Recommendation: Refuse

Proposal: Certificate of Lawfulness of Proposed Development for a rear dining room extension

13 St Giles Close Wendlebury Bicester OX25 2PZ

DOWNSTAIRS FLOOR PLAN

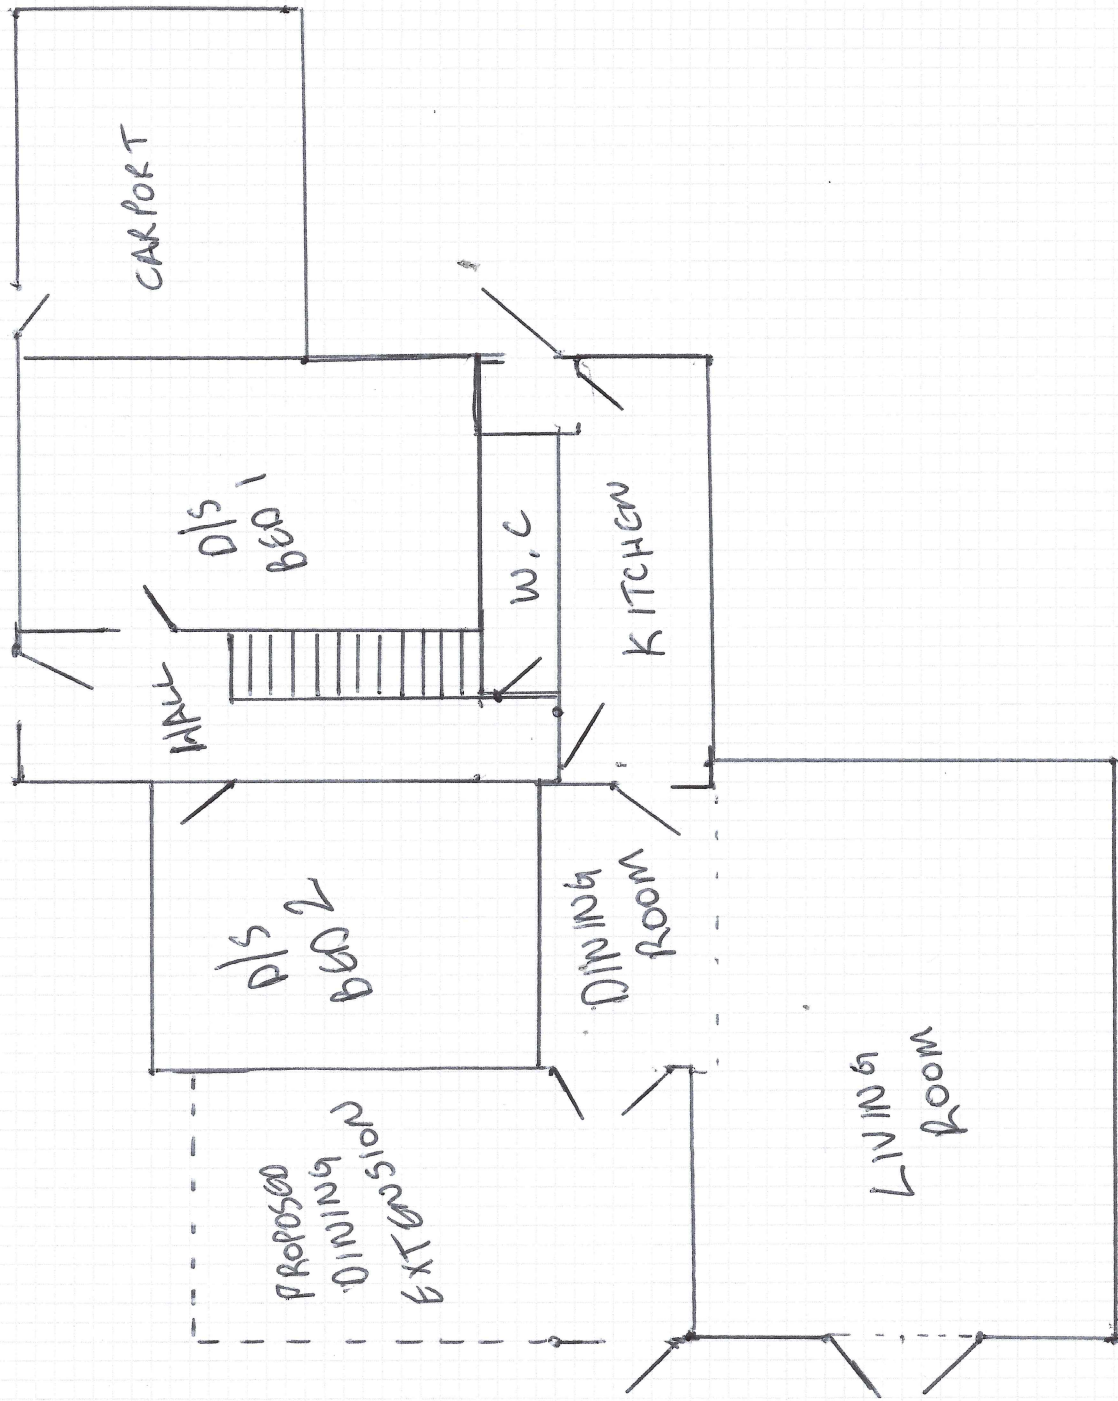
Furthermore, the proposal would abut a previously approved extension creating a wrap around extension. When combined the proposal would represent additions more than half the width of the original dwellinghouse.

SIDE VIEW ELEVATION PROPOSED

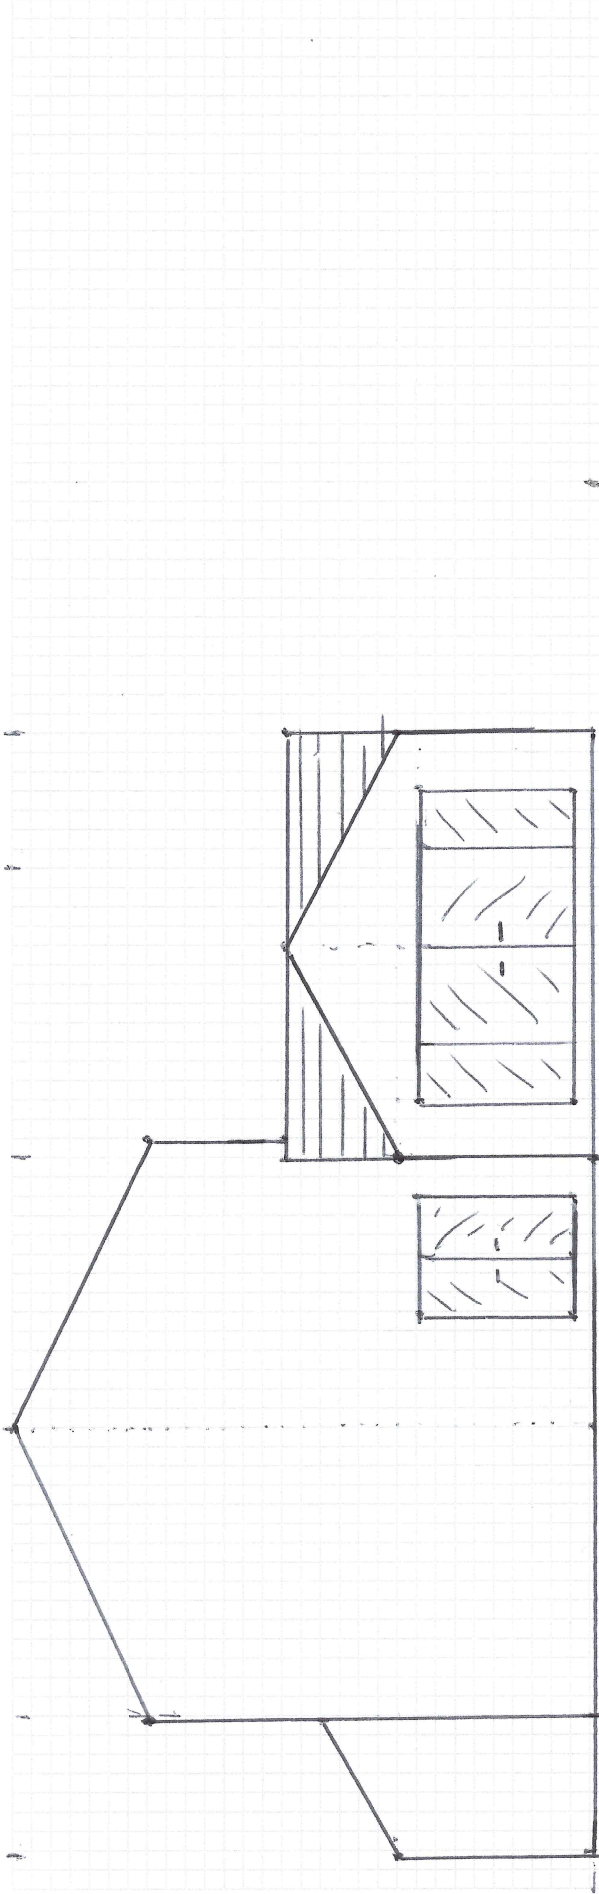
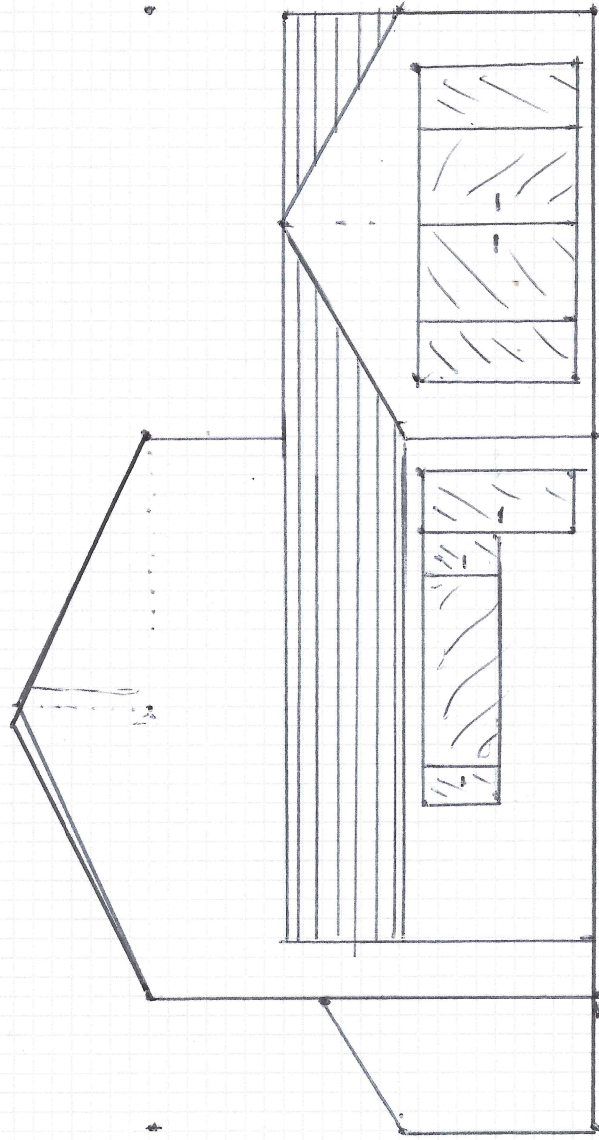
The proposed elevations show that the side extension has a eaves height of 2.75m and a total height of 4.25m.

The single storey side extension would be situated within two metres of the boundary of the curtilage of the dwellinghouse. As such, the height of the eaves must not exceed 3 metres while the total height must not exceed 4m. The submitted plans the proposal has an eaves height of 2.75m and has a total height of 4.25m.

As such, the submitted plans show that the height exceeds this criterion. The proposal does therefore not comply with criteria (J), (i) of Schedule 2, Part 1, Class A of the Town and Country Planning (General Permitted Development Order) 2015 (as amended).
